2 February 2017

File Number: 2017/050492
Our Ref: R/2016/31/A

State Significant Development 7945 – Sydney Opera House Building Renewal Program - Under the Steps, Creative Learning Centre, and Southern Foyers

1 SEATED EDGE SECTION
1:20

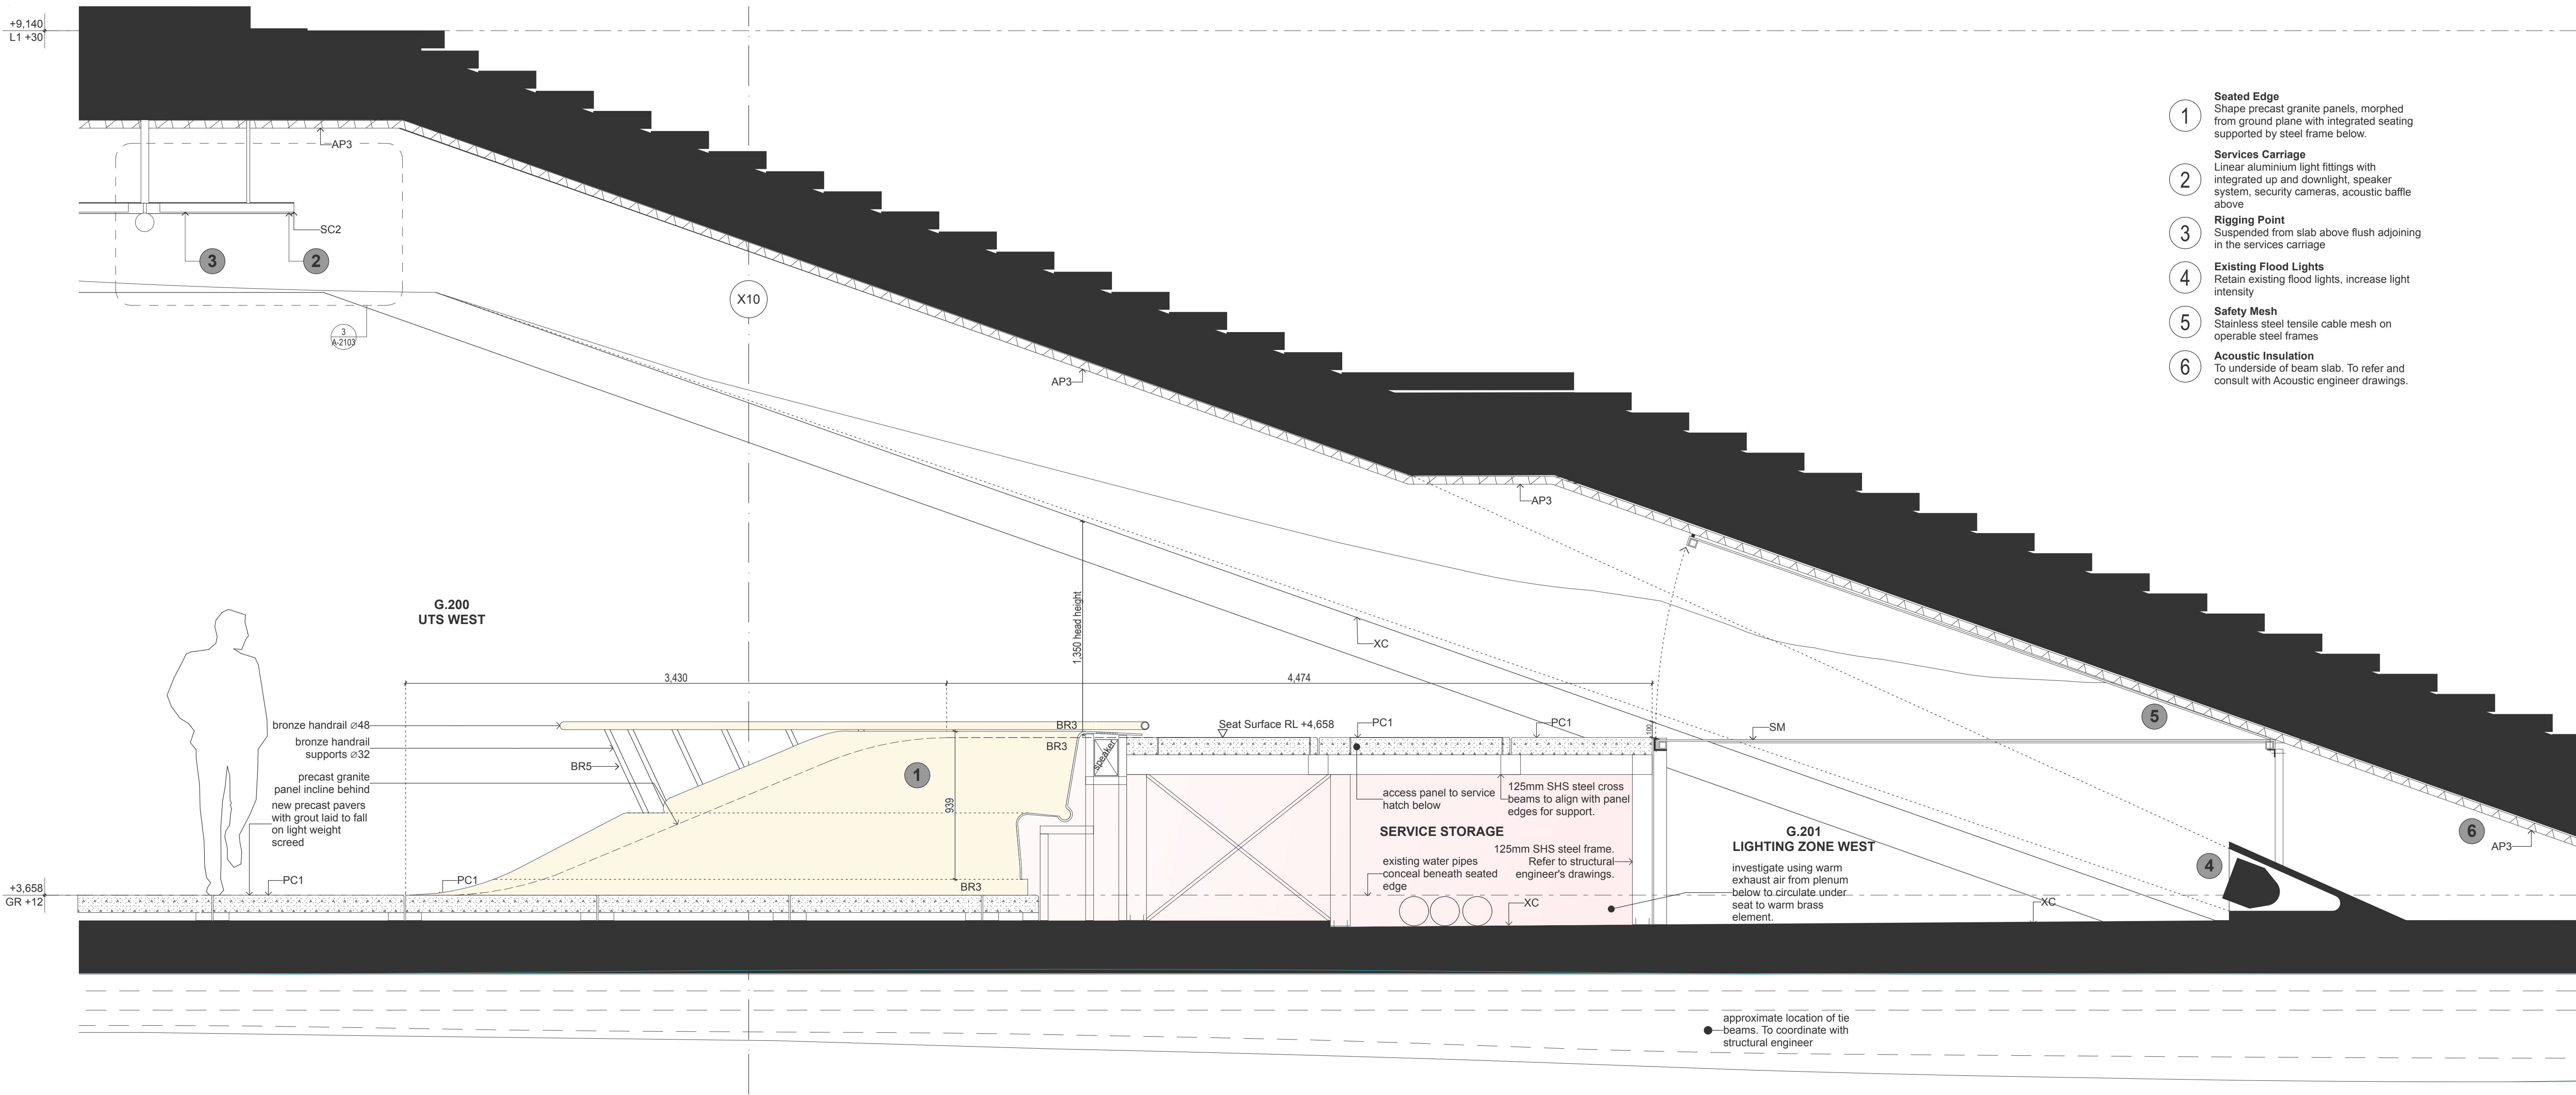
The proposal to demolish significant original fabric beneath the beams supporting the monumental steps, including the original precast granite plinth beneath the steps, and the original precast granite wall panels, is not supported. It is an unacceptable level of change to the significant fabric of the place and it is not considered reversible.

This existing plinth responds to the orthogonal geometry of the space and the powerful lineal geometry of the folded beams supporting the monumental steps. By contrast, the curvilinear forms of the proposed seating platforms do not relate to the powerful and significant geometry of the folded beams above or to the rectilinear plan form of the former vehicular entry space. Whilst the monumental beams have a subtle curvature to their diminishing width at the centre span, this curvature is restrained, and arises out of a structural logic, expressing the changes in the structural forces across the span. The draft 4th edition of the CMP, Policy 5.36 states *'The vehicle concourse should remain uncluttered, offer generous pedestrian space...No permanent or long stay structure or installation should be permitted to encumber or diminish this space'*. This proposal is non-compliant with the CMP in this regard.

Further, City staff consider that the detail of the concave shaped precast granite panels where they intersect with the ground plane will be difficult to achieve as drawn on the submitted plans.

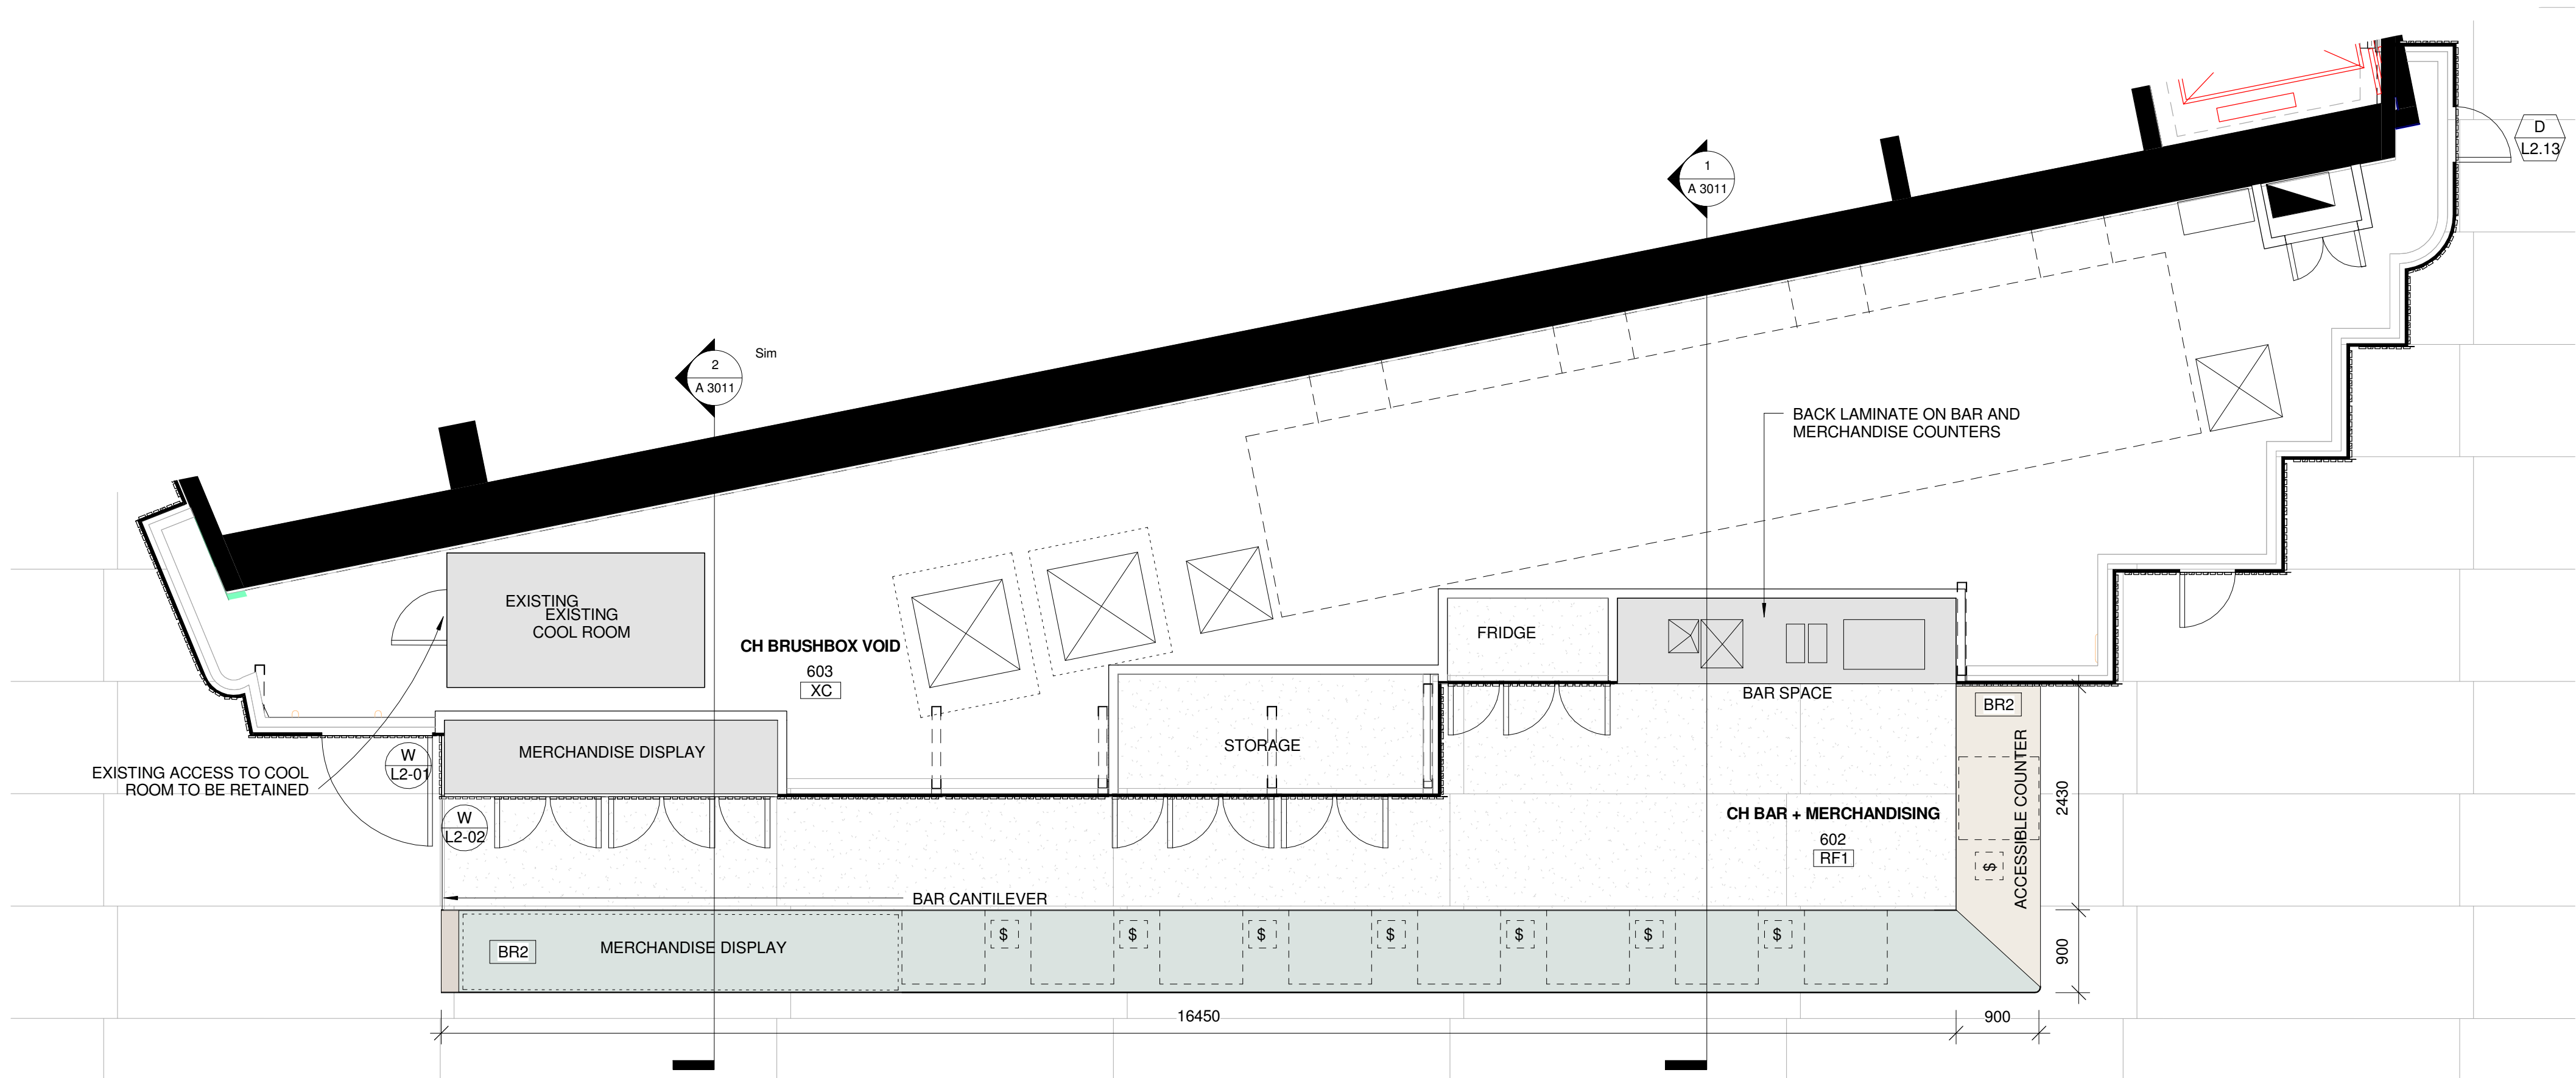
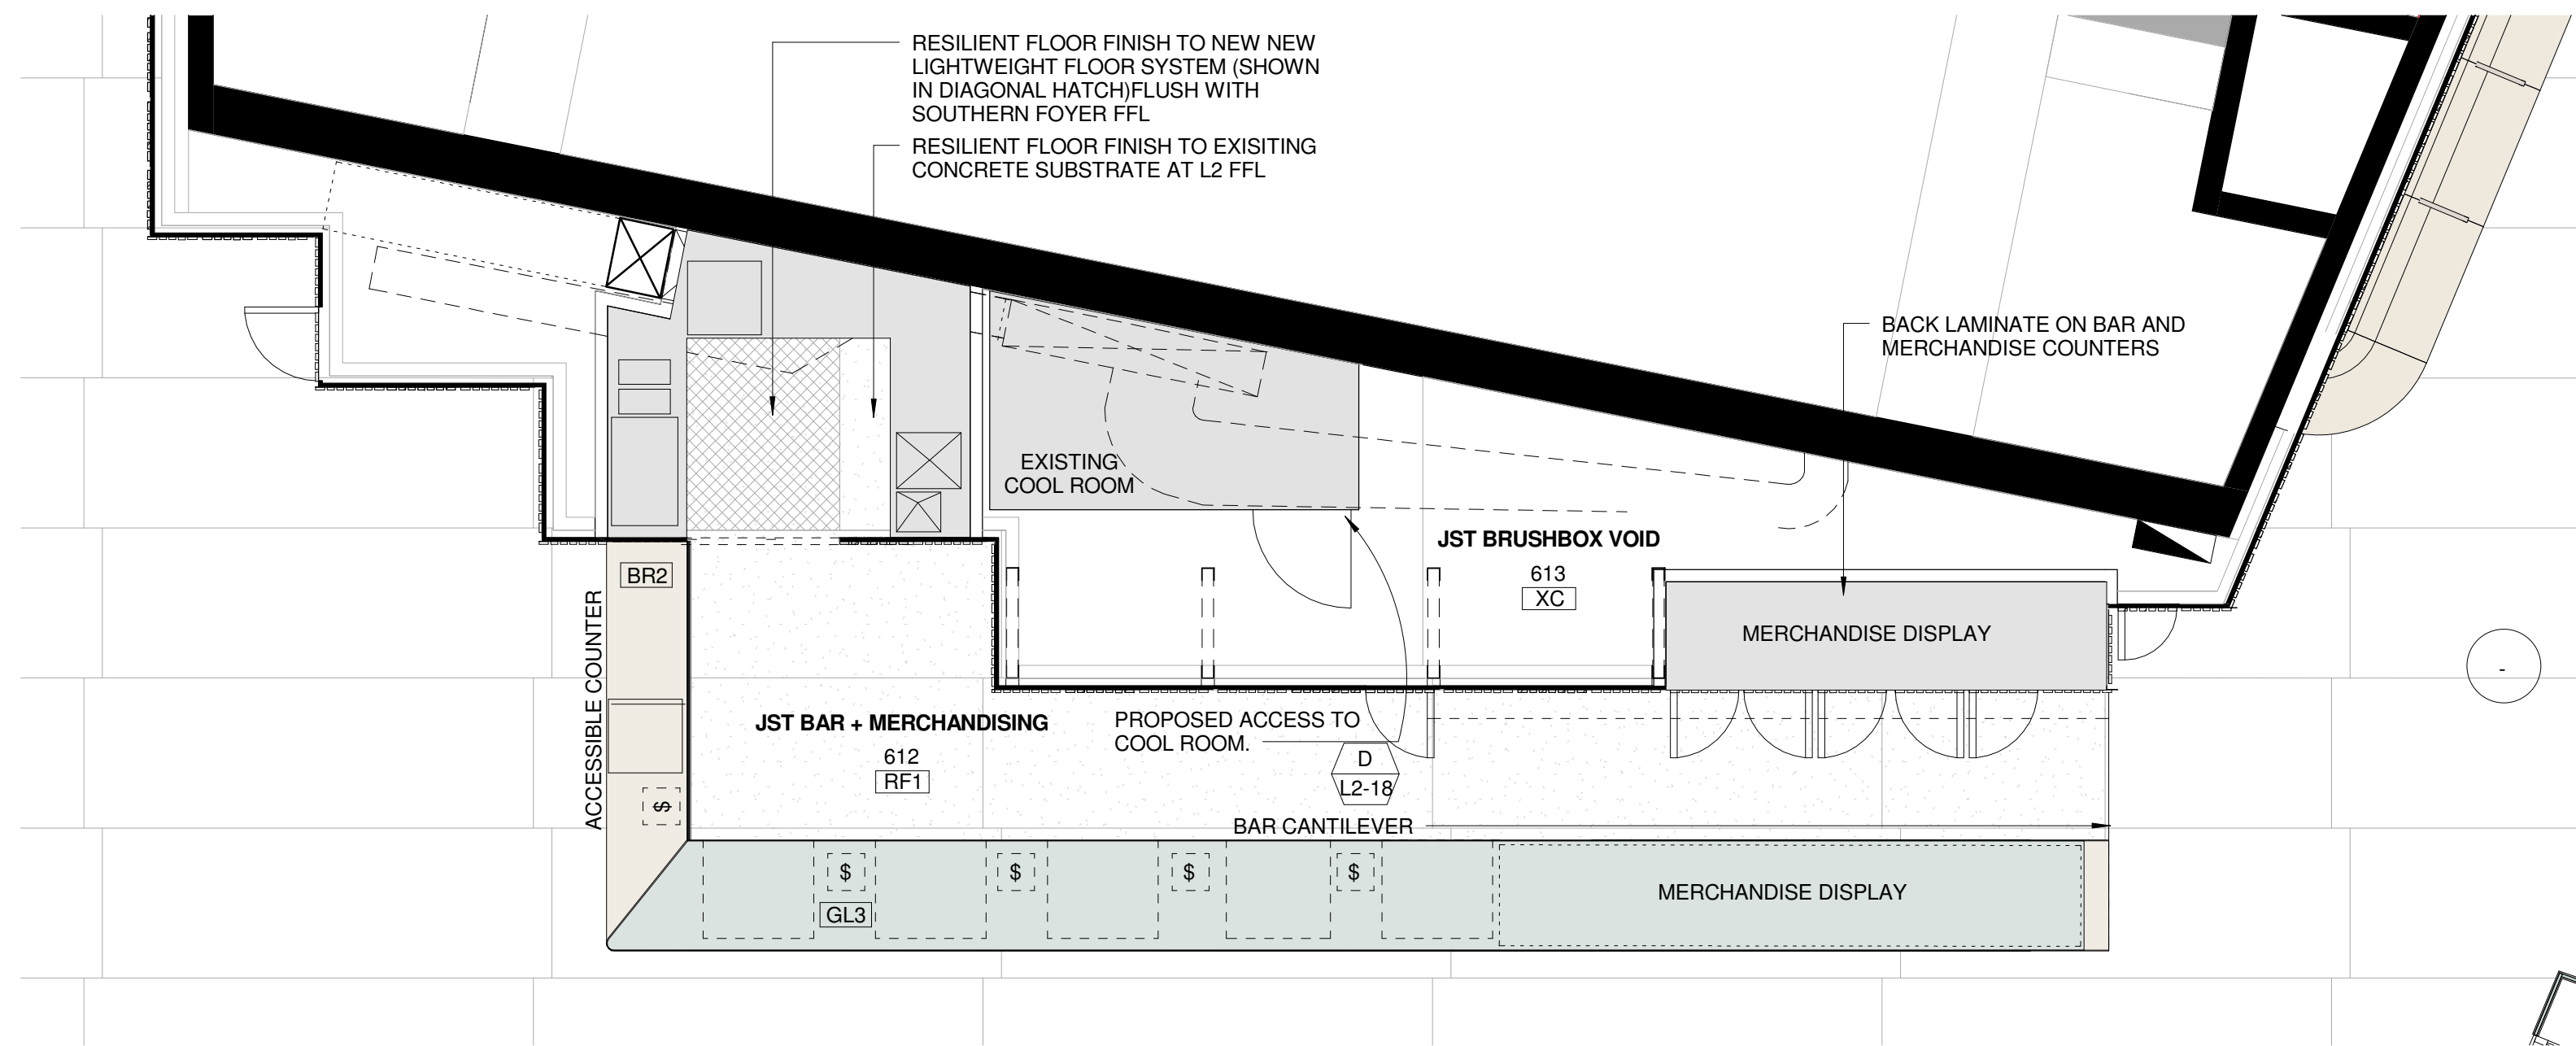
The proposed lineal bar against the wall of the CH auditorium and the proposed digital screens are not supported, as they will become the main visual focus as patrons ascend into the space from the lower foyers. Their placement results in the merchandising becoming the primary function of the space, whereas the main function is, and should remain as, a gathering space. The proposed digital merchandising display screens will detract from the character of the place, and the proposed materials of the counters do not relate to the original palette of materials in the foyers.

The proposed linear counters are not supported in the submission by an analysis of pedestrian numbers and movements. It would appear that the counters will partially restrict patron movement from the southern foyers into the CH western foyer and the JST eastern foyer, whereas the original freestanding bars permit the free flow of patrons. It is noted that the original circular bar in the concert hall southern foyer, if relocated slightly to the south of its current location, would increase the width of passage around into the western foyer.
